**WEST SUSSEX COUNTY COUNCIL  
PLANNING SERVICES CONSULTATION**

**DATE: 10/10/2017**

**SUBJECT: LU/287/17/PL - Demolition of existing buildings, change of use & erection of 1 No. building incorporate office (B1) at ground floor & 8 No. dwellings at first floor level.**

**46a & 47, Pier Road & Land north of Clifton Road, Littlehampton, BN17 5LW**

drawing **Proposed site plan**

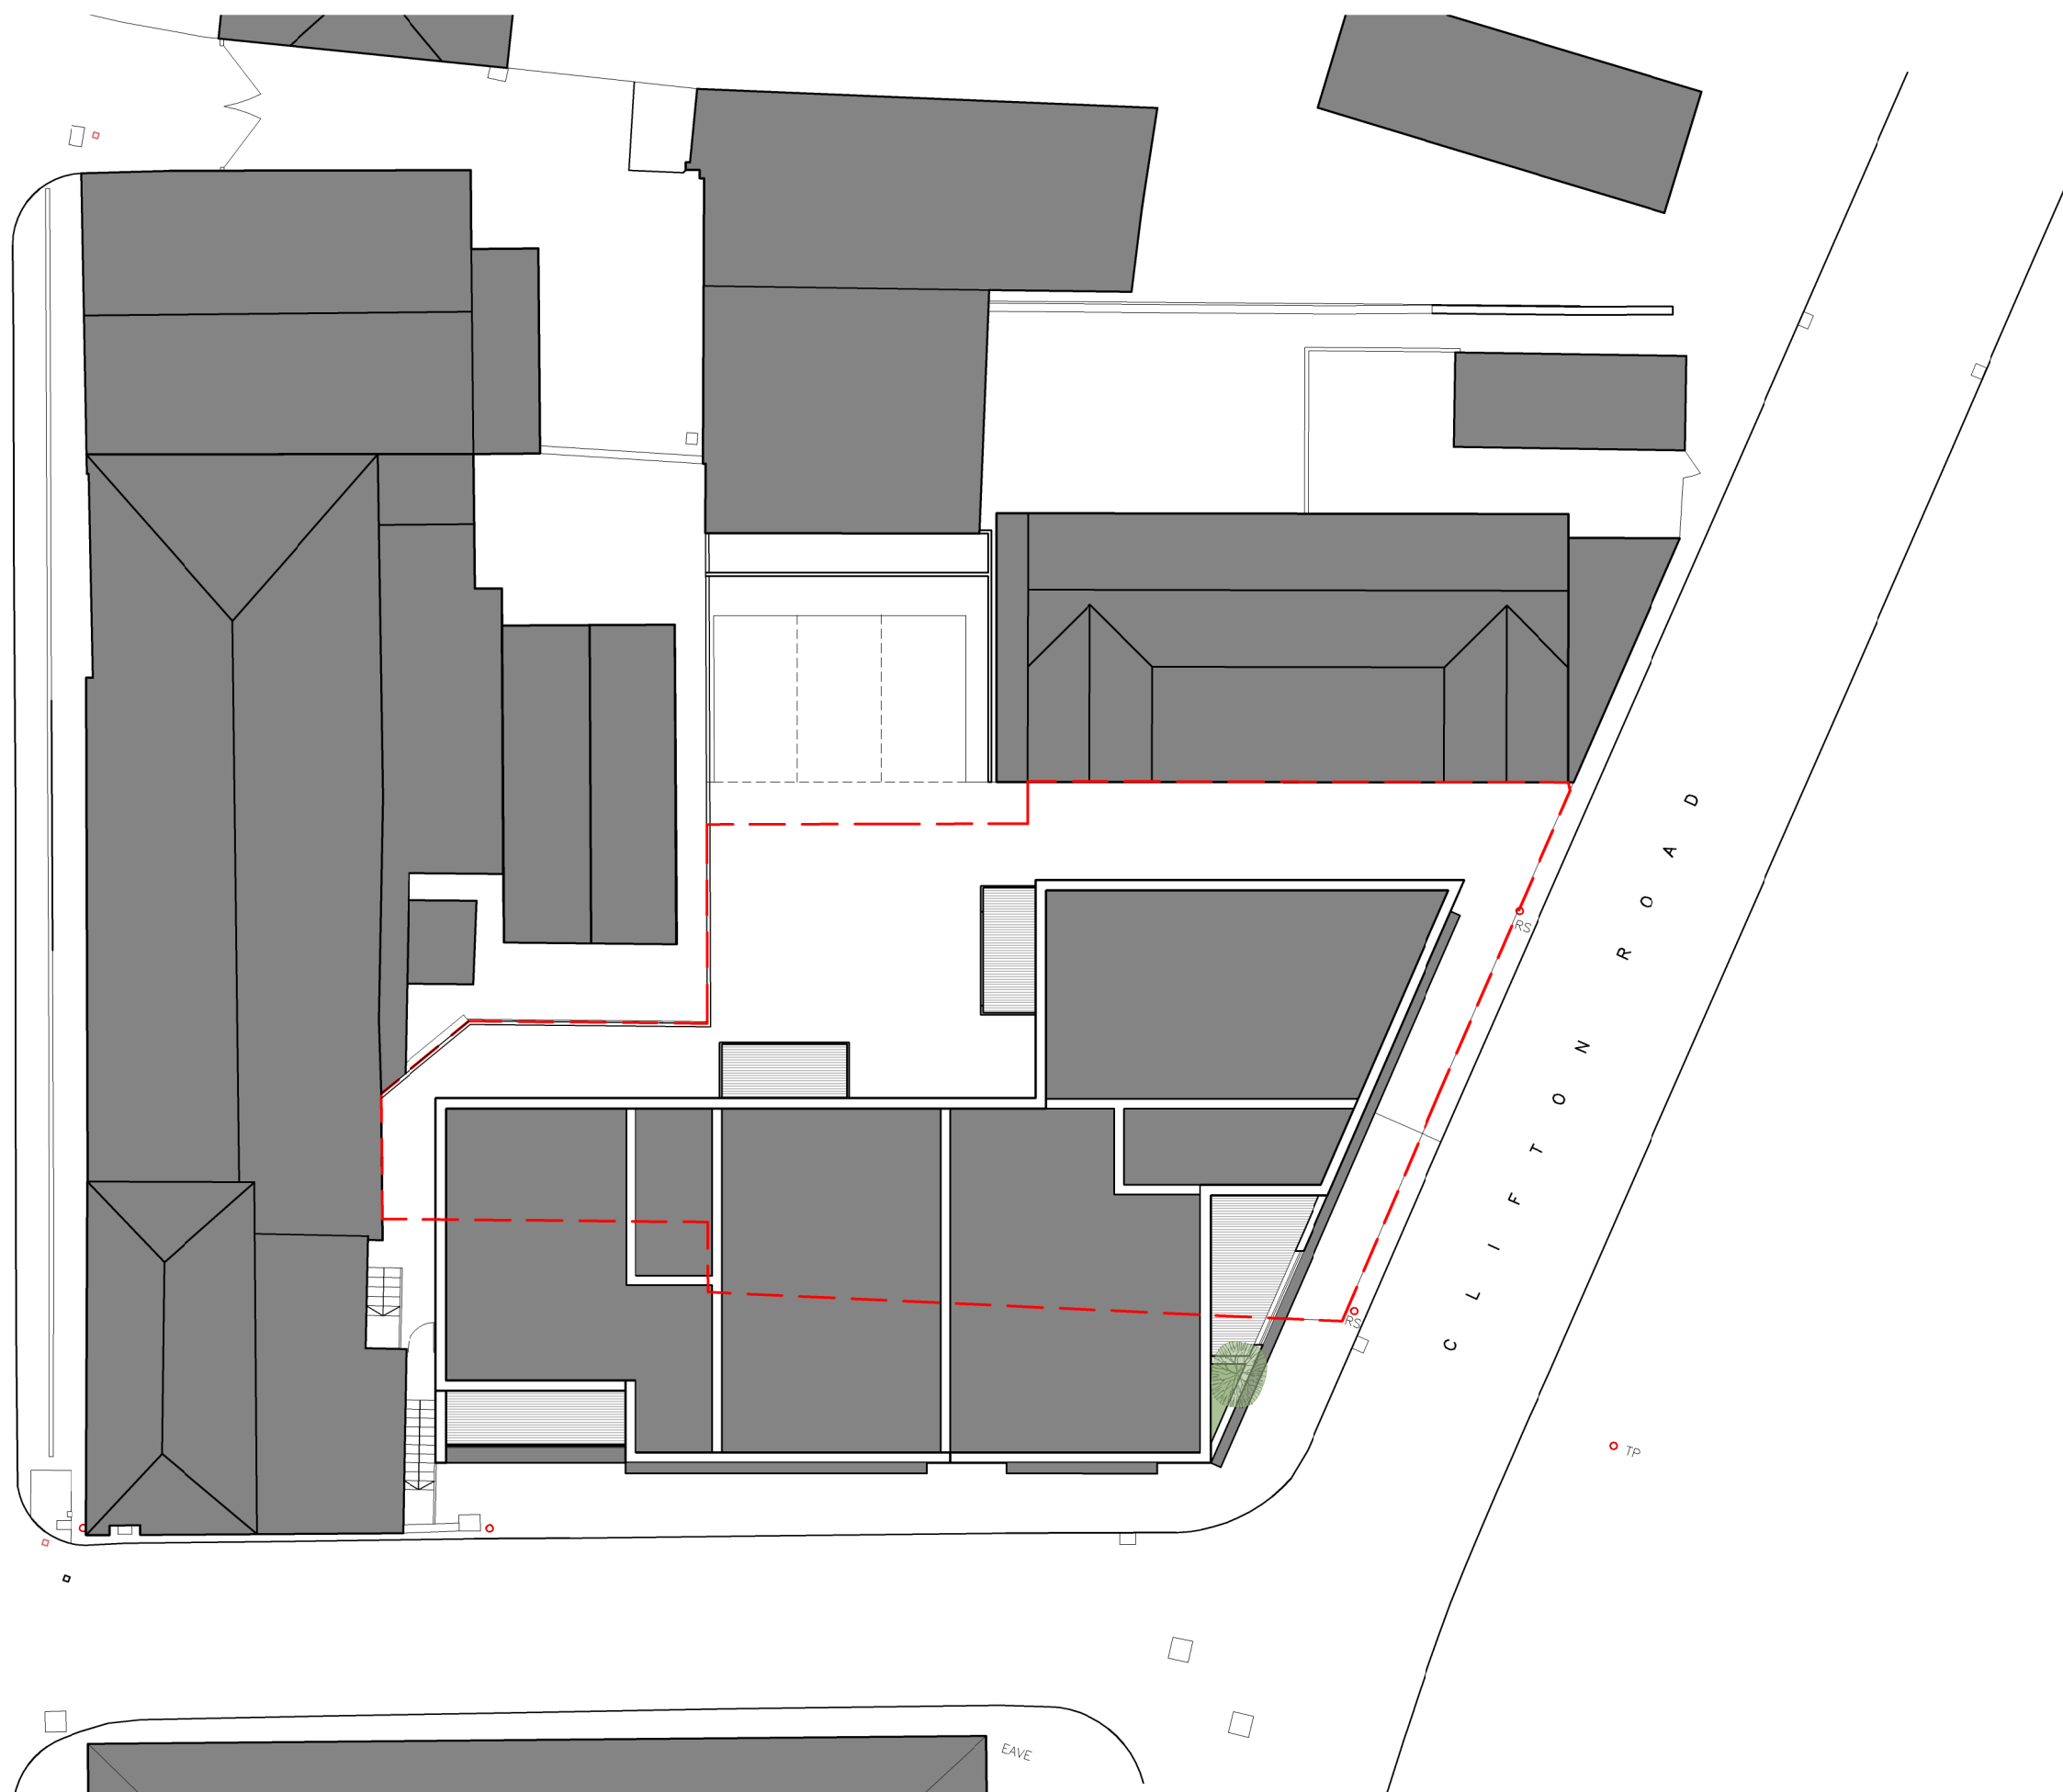
It is proposed that an opening immediately south of 1 Victoria Gardens will provide vehicle access into the site and serve the proposed car parking spaces in the forecourt. A separate opening approximately 6 metre wide will provide access to under croft parking for two vehicles with access to an additional two under croft spaces possible independently from within the site.

Whilst the new building line will be set back providing some vehicle visibility to the south the existing building of 1 Victoria Gardens immediately to the north will restrict visibility in this direction upon exiting the site. The LHA acknowledge that vehicle visibility at the existing points of access is restricted on site under the existing industrial use however the re-development of the site does provide the opportunity to improve this.

The LHA would request the applicant re-consider the proposed access arrangements. Given the type of development proposed any access point into the site should be wide enough for two cars to pass in opposing directions (4.5m). Re-location of the access further south would require modification of the proposed under croft car parking though provides the opportunity for improved vehicle visibility and allow for the formation of pedestrian visibility splays either side of the access.

A significant majority of the dropped crossing along the southern and eastern boundary of the site will be redundant as a result of this proposal. The existing dropped crossings in these locations should therefore be raised. The footprint of the proposal will then provide the opportunity to secure a 2m wide footway around the southern and eastern boundary of the property. This would allow for pedestrian link to adopted public footway which would improve the accessibility of the site for this sustainable mode of transport. The works would require implementation under a combined S278/38 agreement.

The applicant should also note that the existing Traffic Regulation Order (TRO) sign will need re-locating at their expense for the proposed access works to take place.

Nine spaces for the residential units are proposed, it is not clear whether these will be allocated and whether one is proposed for the existing residential unit, no. 47 Pier Road, shown on the plans. On the basis of the parking remaining unallocated the new residential units would result in a total demand of seven spaces.

The applicant should consider modifying the access arrangements as described in the 'Access & Visibility' section above, to allow for improved width of access and visibility. A re-arrangement and reduction of parking may result though the LHA will assess this on balance with improved access arrangements being provided.

The applicant would also be advised to demonstrate the workability of any amended parking layout via swept path plans.
